LSC TRANSPORTATION CONSULTANTS, INC.
2504 East Pikes Peak Avenue, Suite 304
Colorado Springs, CO 80909
(719) 633-2868
FAX (719) 633-5430
E-mail: lsc@lsctrans.com
Website: <http://www.lsctrans.com>

July 2, 2020

RE: Palmer Park and Powers Commercial Center
El Paso County, Colorado
Traffic Impact Study
LSC #174760

Figure 3a

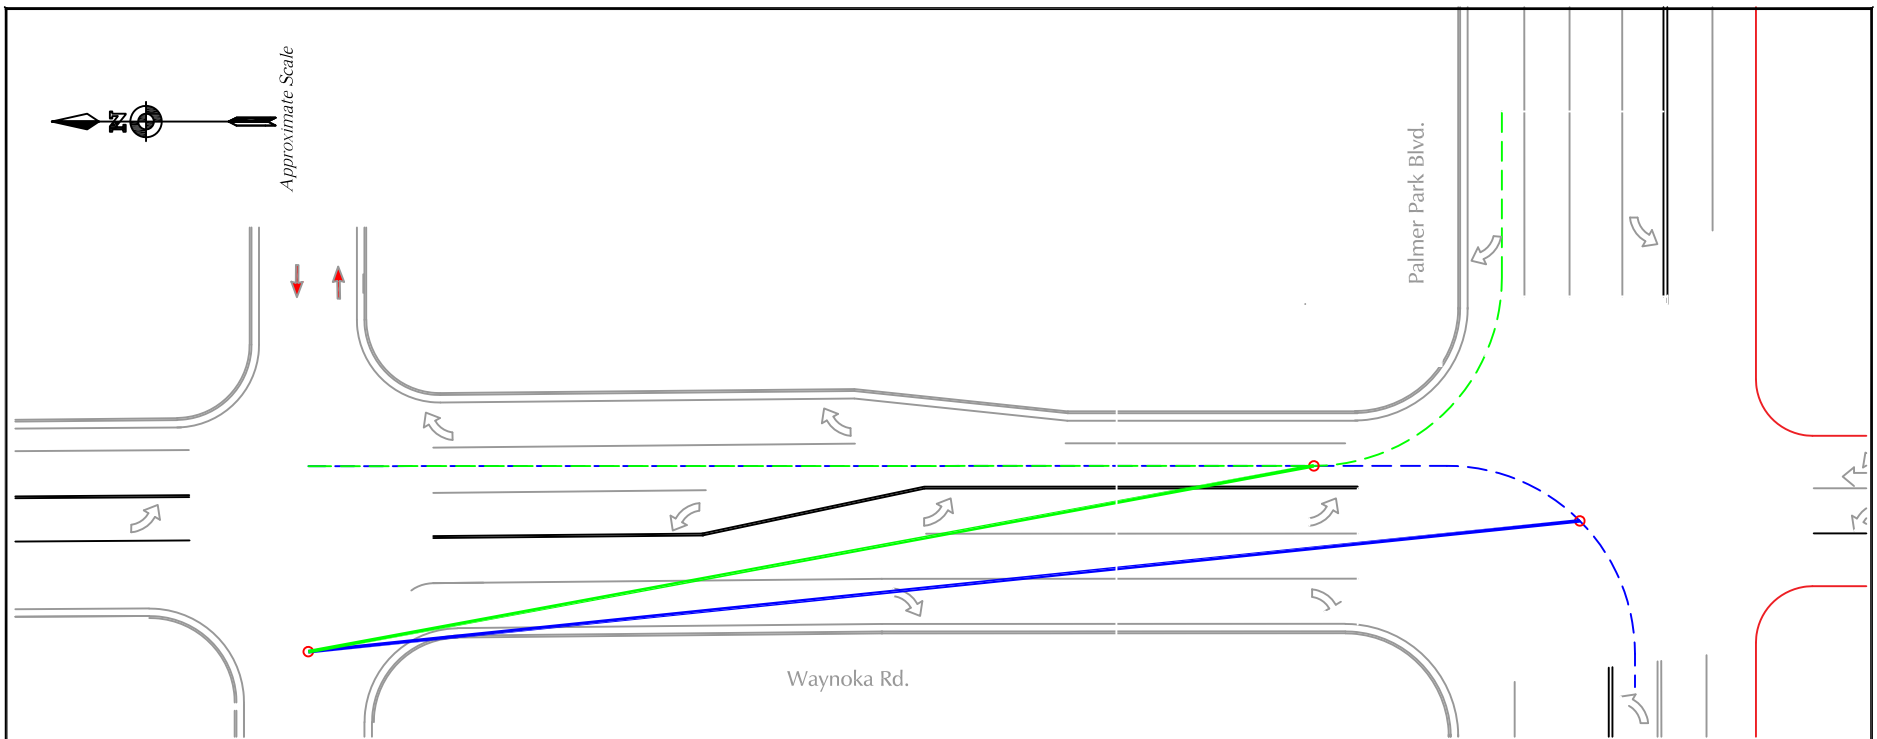
Please indicate the slower speed of vehicles turning at intersection and indicate the AASHTO distance for that speed and whether the distance available is acceptable.

Please explain in your narrative why multi-unit trucks has not been utilized as indicated in ECM table 2-36 for commercial land uses.

## Recommended Palmer Park Boulevard Improvements

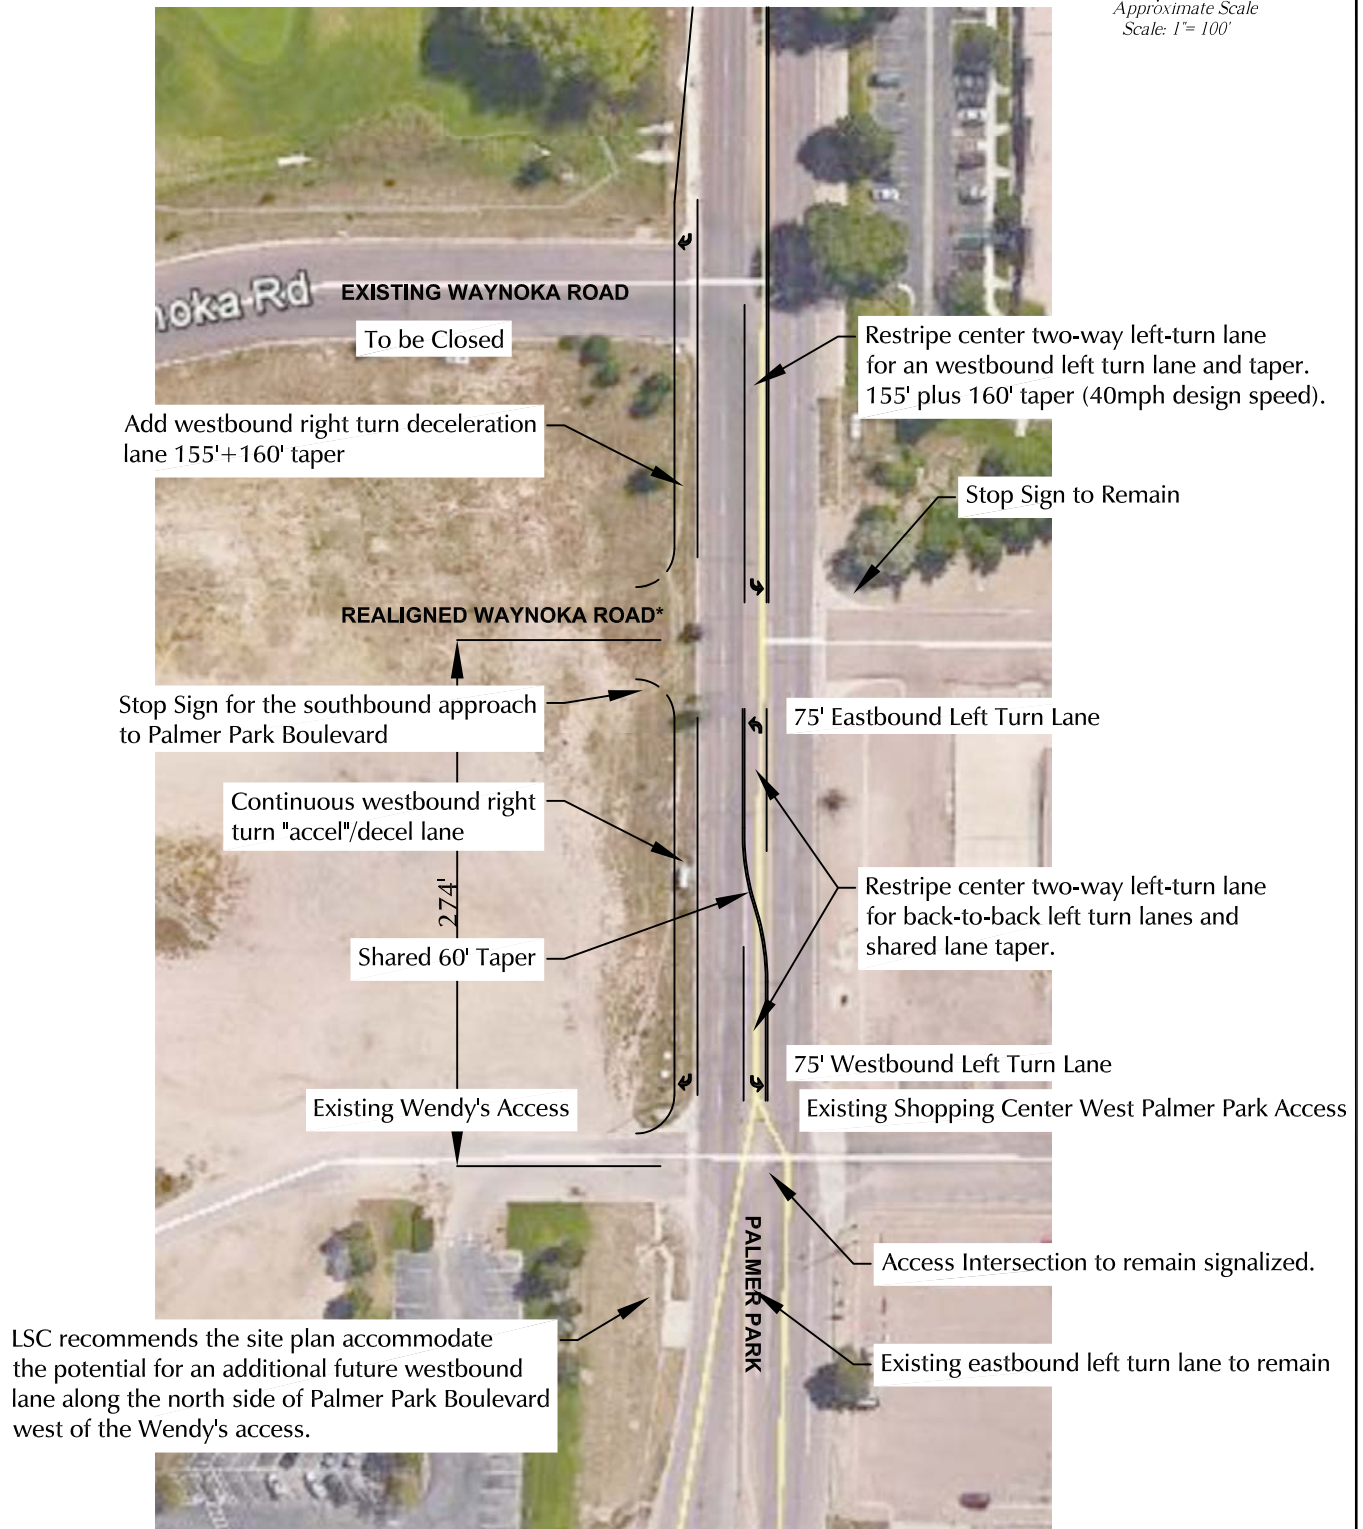
Please provide the turn lane designs for the southbound left turn lane at Waynoka/Palmer Park intersection. Please also provide the turn lane designs for all other auxiliary lanes along Waynoka at the proposed access points. Be sure to indicate the ECM criteria and whether it can be met.
